EPC STORMWATER REVIEW COMMENTS
 IN ORANGE BOXES WITH BLACK TEXT

EL PASO COUNTY GRADING AND EROSION CONTROL PLAN CHECKLIST

EPC Project Number: **VR2323**

NO. 9

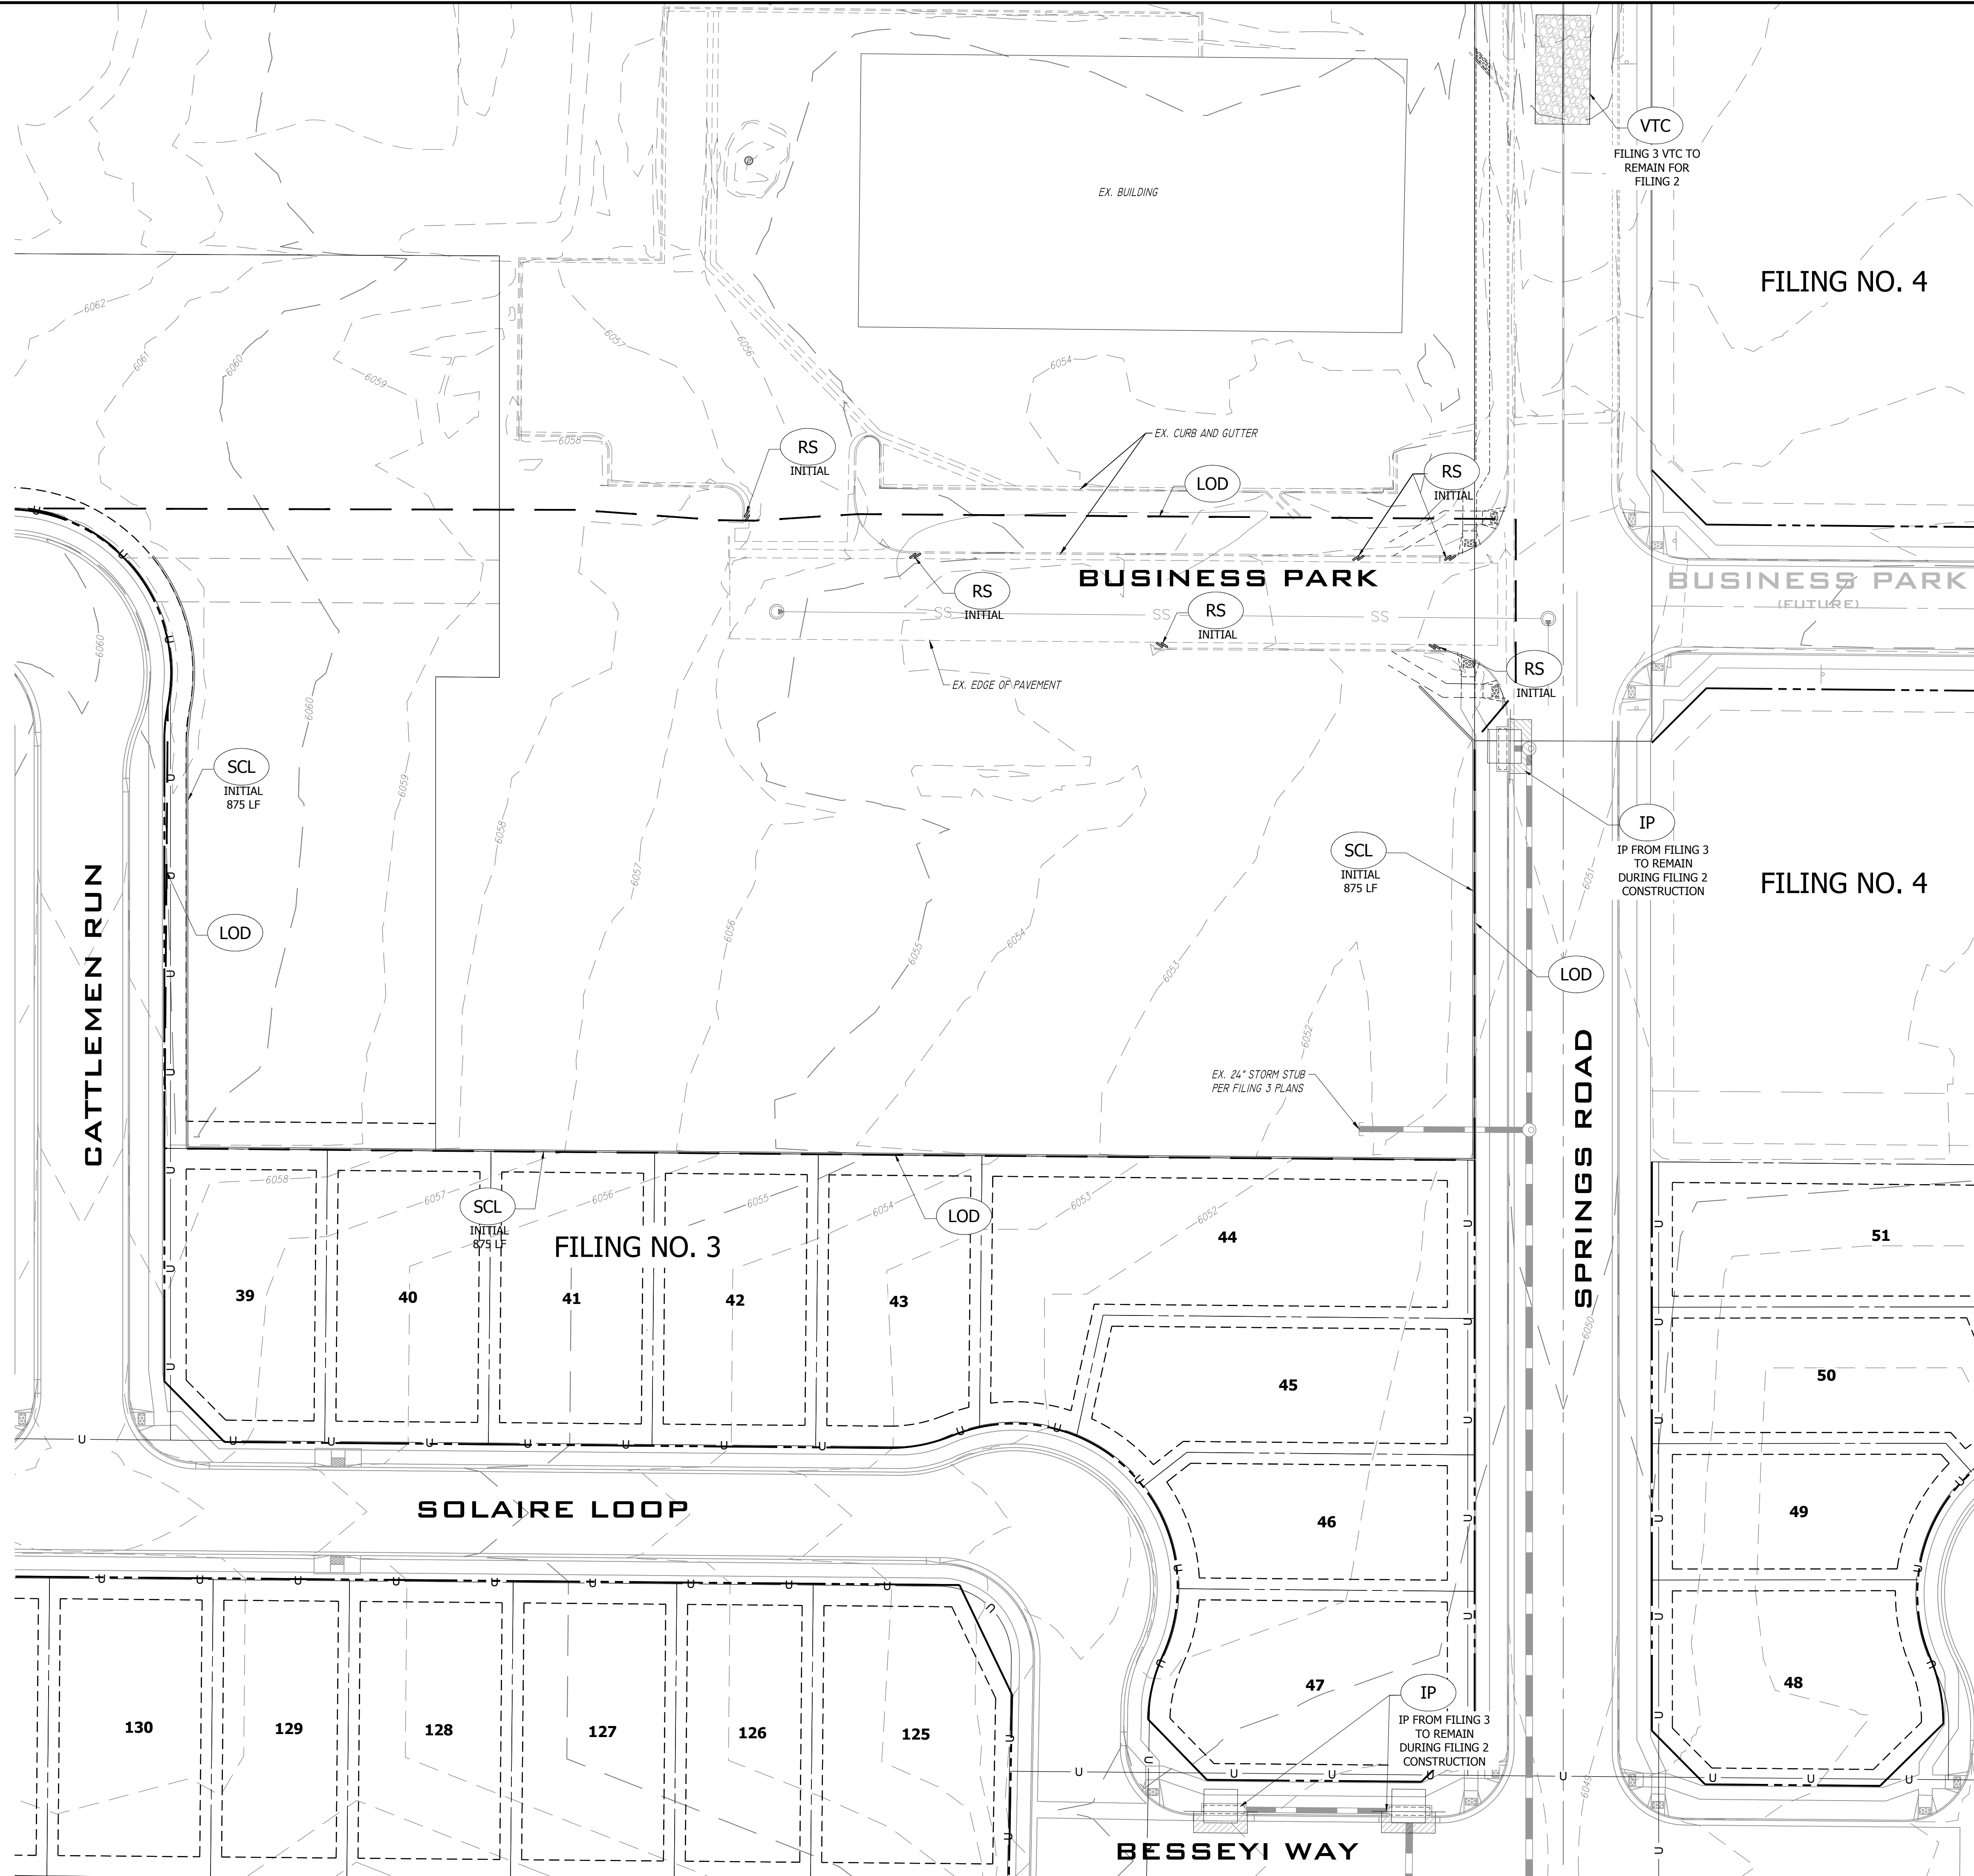
Verify. Y is selected, but there is no obvious off-site grading. If applicable clearly delineate and label as off-site grading. Or put N/A if not applicable.

This was an error on our part. No offsite grading is proposed and the checklist has
